Heritage Advice

Buildings 130 and 131 Technical Workshops at Bicester Heritage - Reference 18/00827/F

Garry Campion, Senior Conservation Officer

14.6.2018

WEST ELEVATION UNIT 131

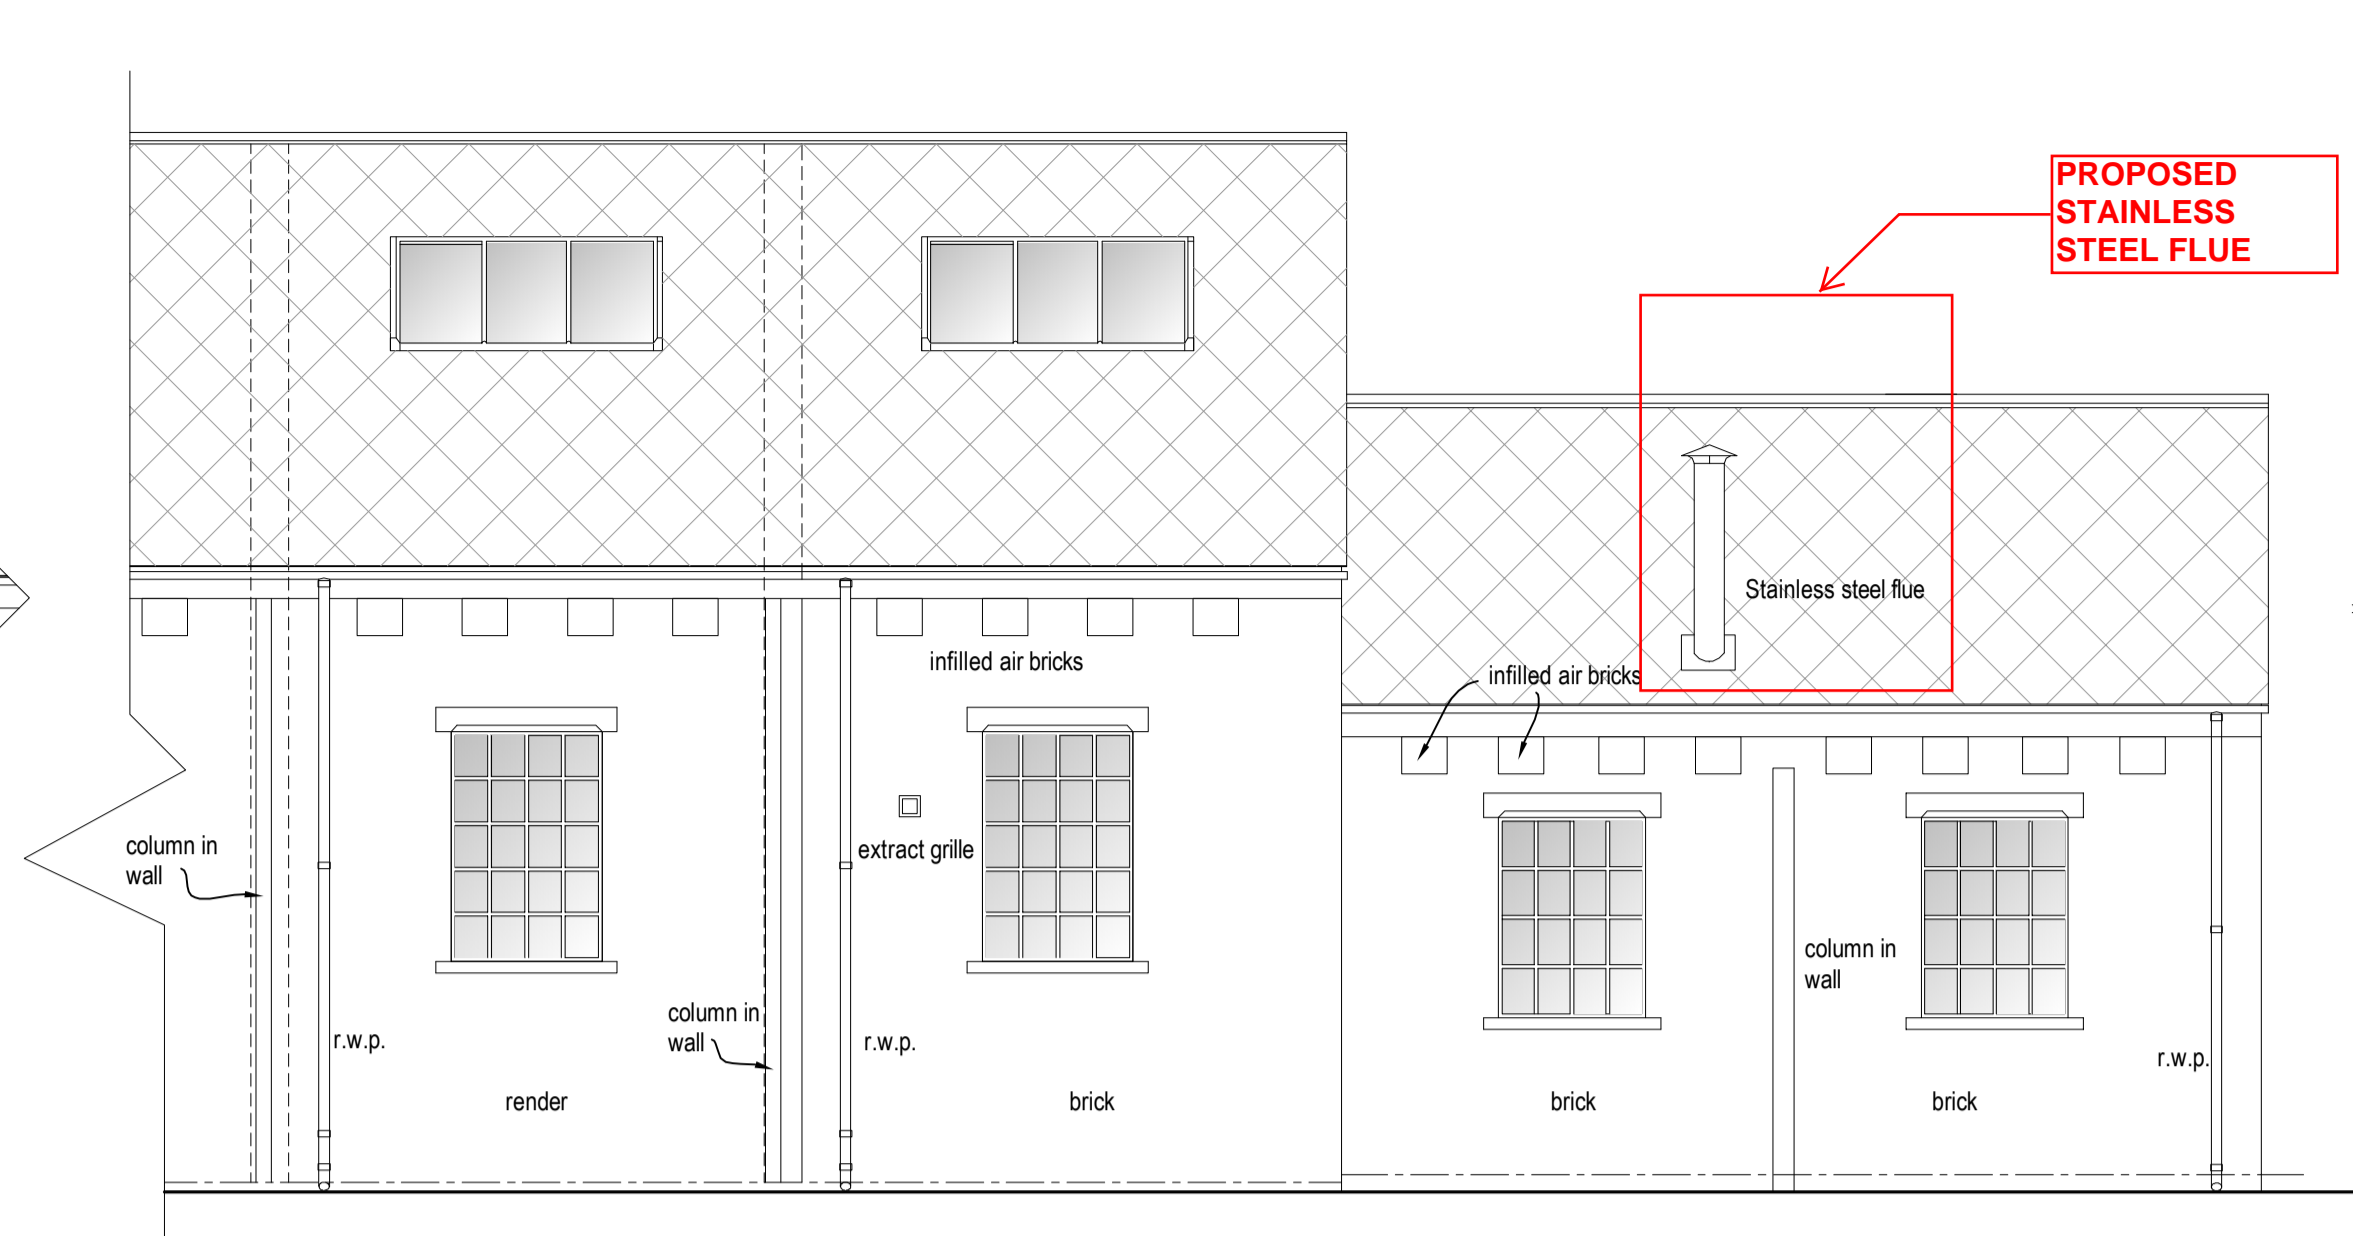
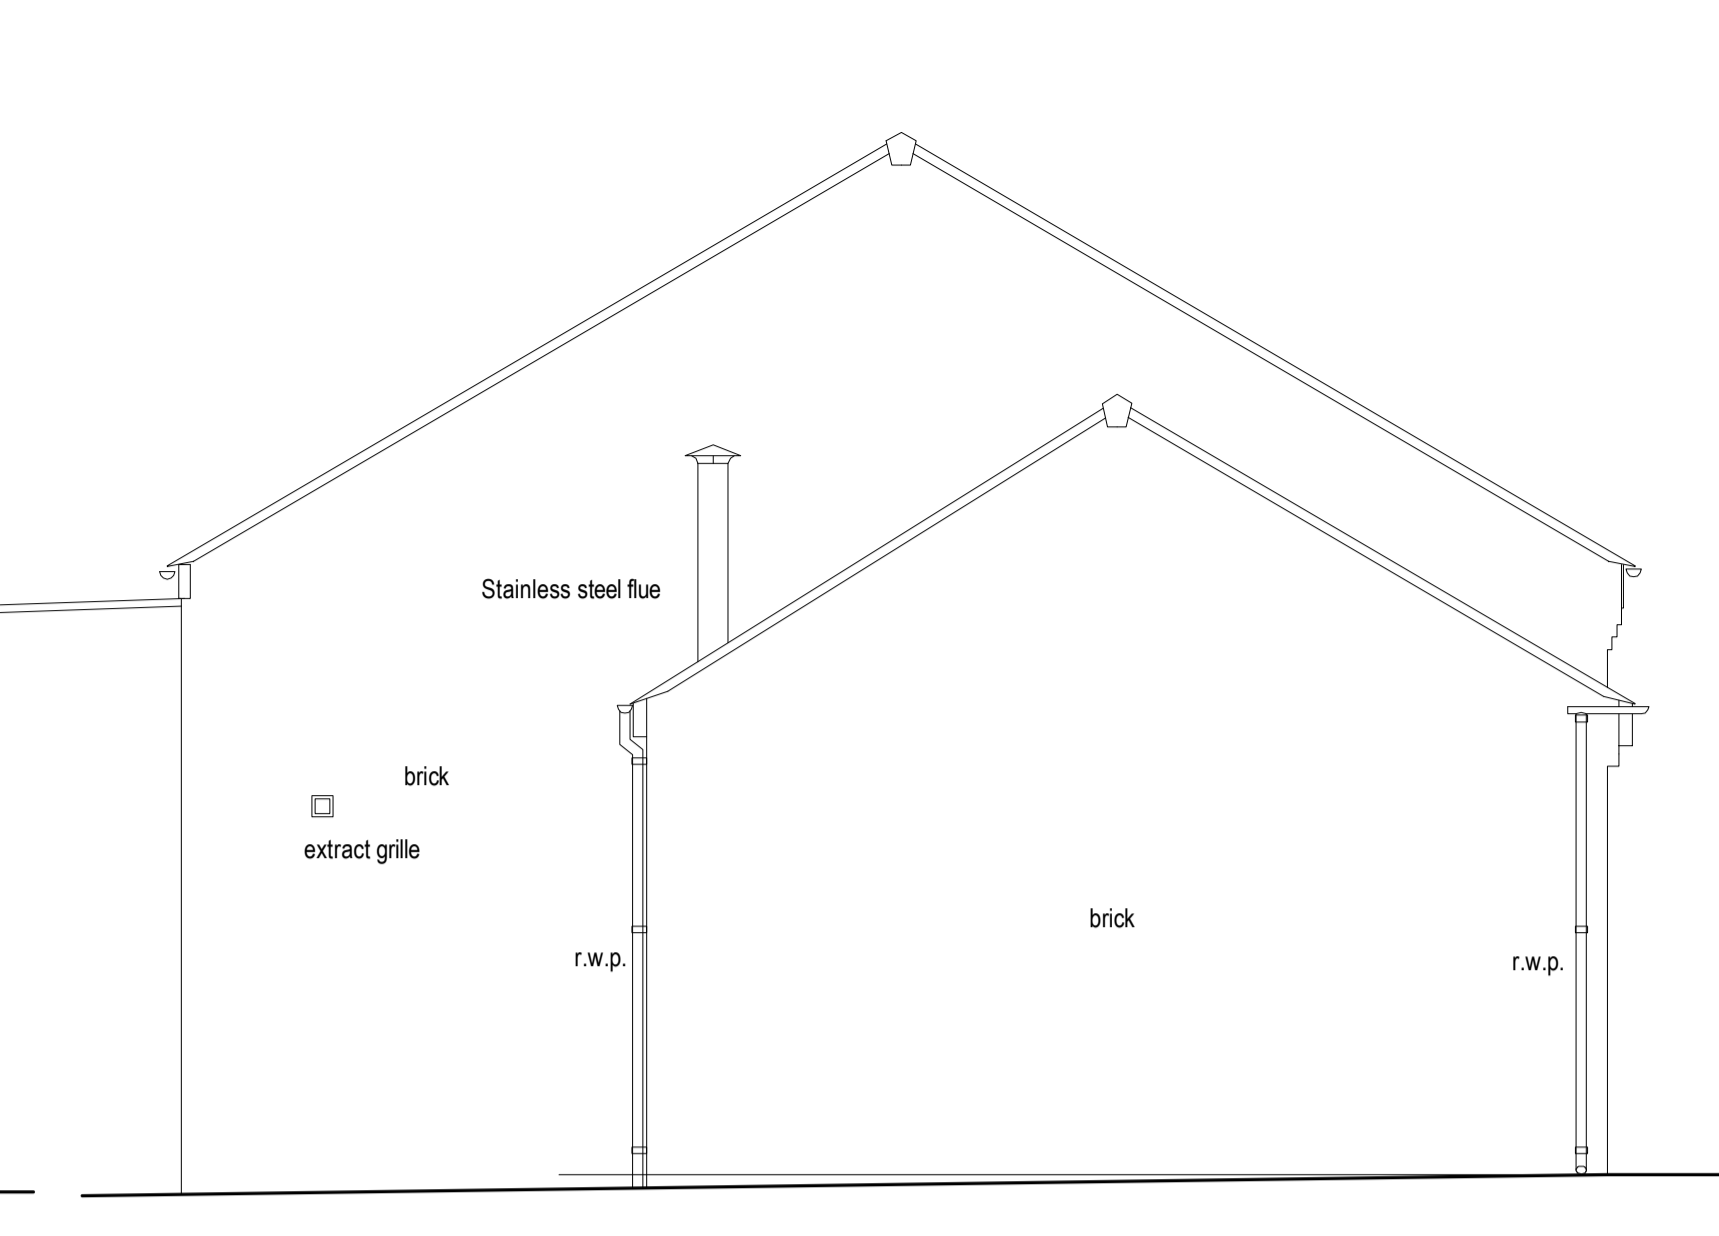
Specifically, in Building 131 a new stainless steel flue is proposed to be installed in the existing pitched slate roof with minor adaption of the roof covering disturbed by the new chimney.

The proposed works will have little impact upon the significance of the two buildings. Whilst the flue will be visible to the rear elevation, this should be balanced against the successful use of the building by the current tenants. It will not be visible from within the courtyard area where most activity takes place. The roofing is later and is not harmed by the modification to insert the flue.

FLOOR PLAN UNIT 130

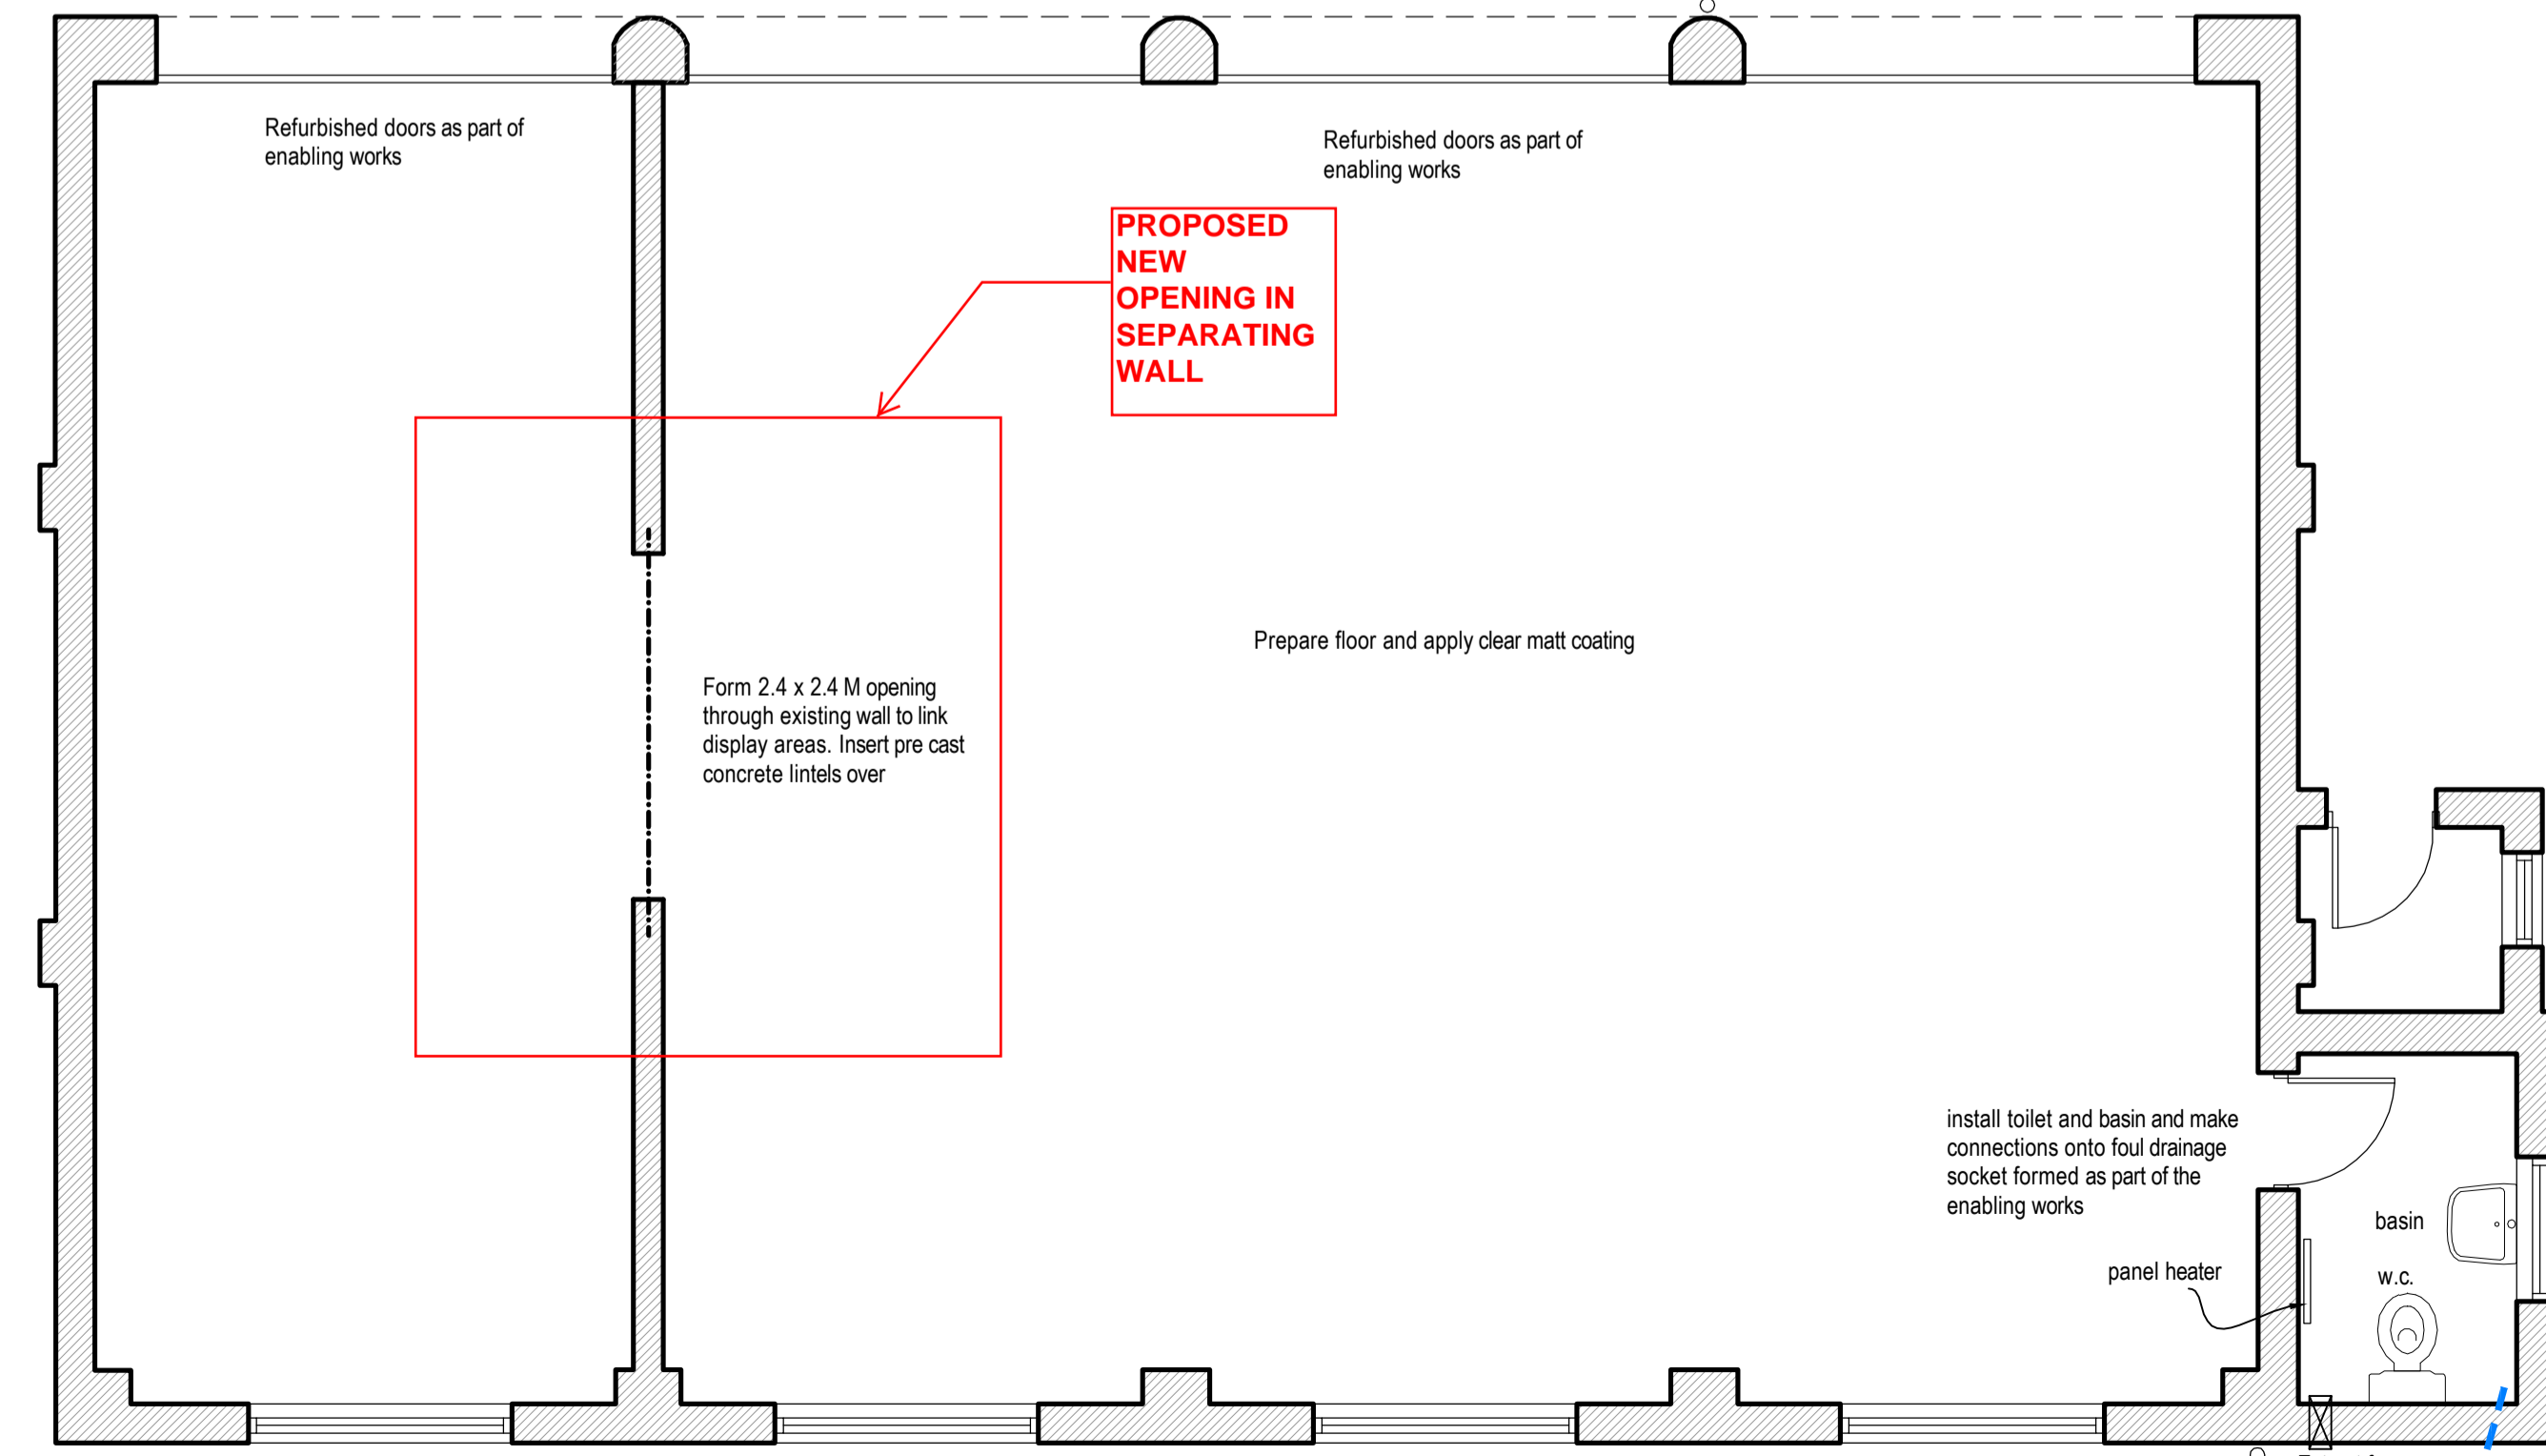
In Building 130 it is proposed to form a new 2400 x 2400mm high opening in the brick separating wall, with decoration and details being made good to match as detailed in the HPA for the site. The buildings are in the former airfield Conservation Area.

The proposal to remove the central section of the internal brick-wall will enable a better use of the workshop space. This large expanse of walling is of single brick thickness and rises to the building

ridge, but is otherwise unremarkable. Originally, it separated the workshop's bays. The proposed opening will allow for better modern use of the workshops, but will not prevent an understanding of the earlier internal arrangements.
